Environmental Health Consultation Response	Officer	Alan Taylor
---	----------------	--------------------

Description:	Dunsop Bridge, Clitheroe Lancashire BB7 3BB		 Ribble Valley Borough Council www.ribblevalley.gov.uk
Application Ref:	3/2017/0408	Case Officer: Mr Robert Major	
Response Ref:	3/2017/0408/ENV/01	Issue Date: 7 June 2017

Thorneyholme Hall - Proposed Site Layout

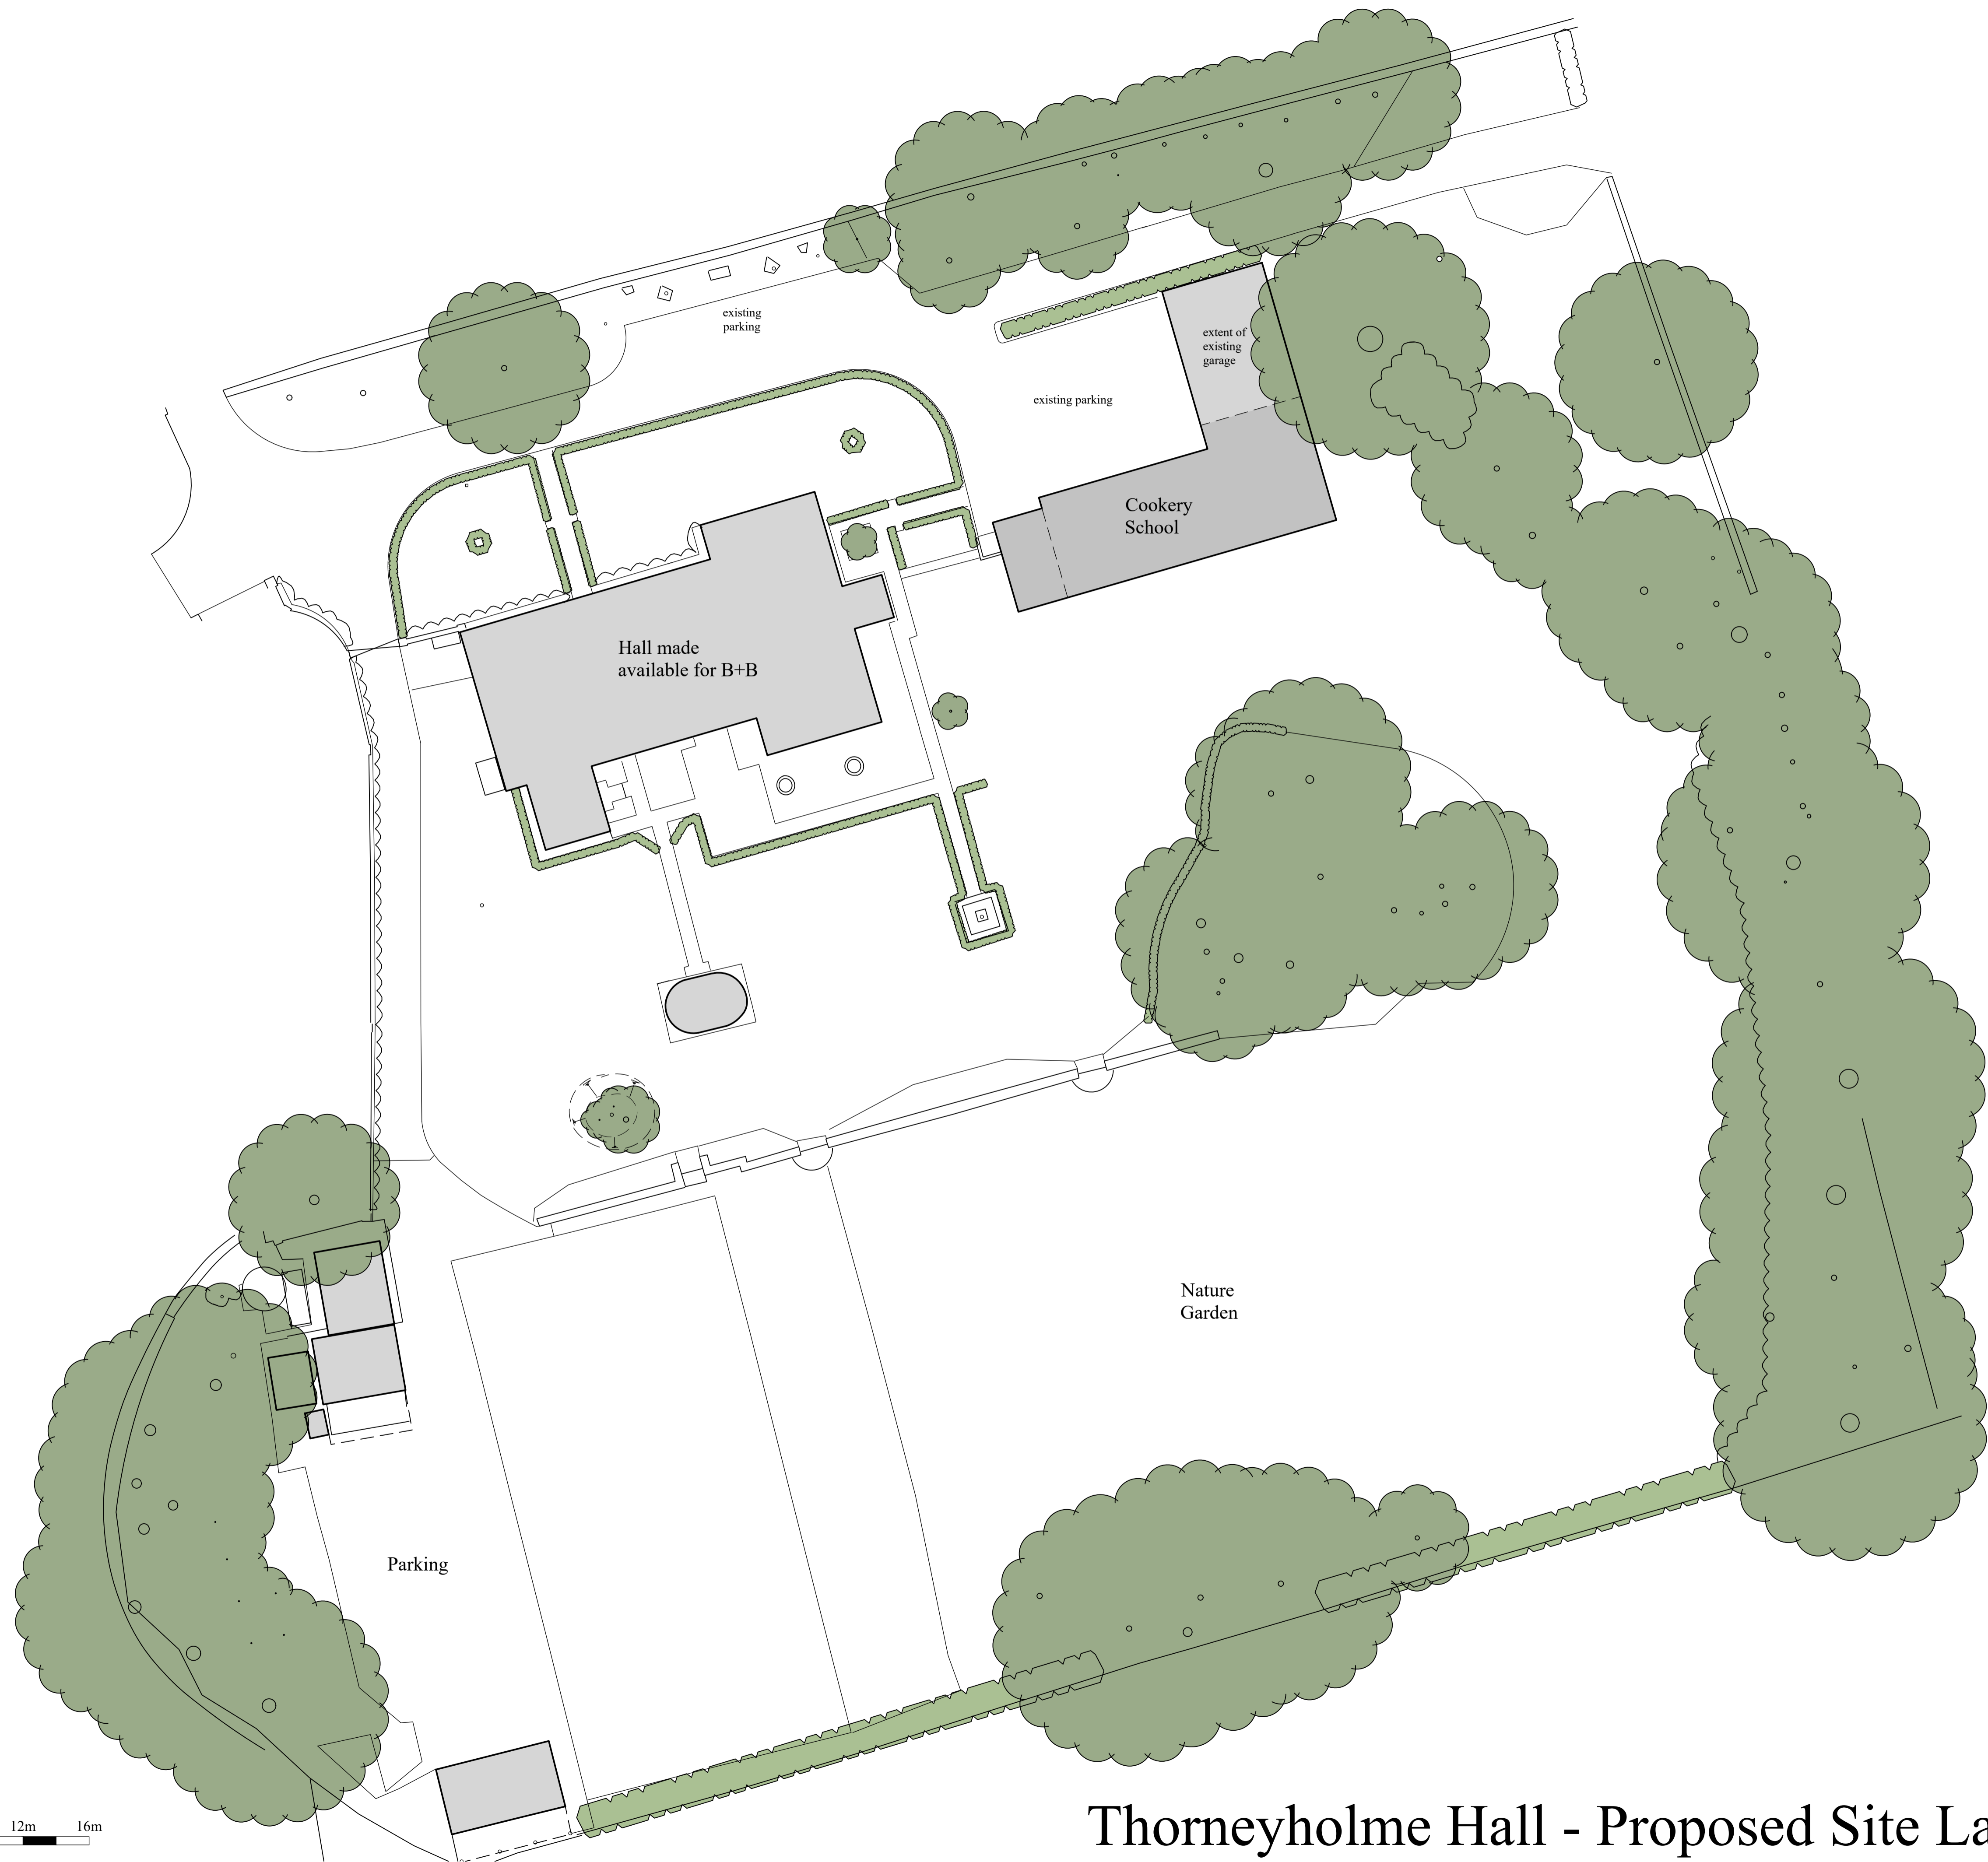
General Comments/Observations	
1.1	The cookery school is a separate from the main building, there is no external lighting indicated on the proposed site plan.

2.5	Should you be minded to approve the application, notwithstanding other considerations, I would suggest that the following conditions be attached should you feel they are relevant and justified: <ul style="list-style-type: none"> If any new external lighting is to be introduced following the new construction the lighting must not extend beyond the boundary fence of the current site. This is to reduce the incidence pf complaints from neighbouring premises.
	Officer: Alan Taylor
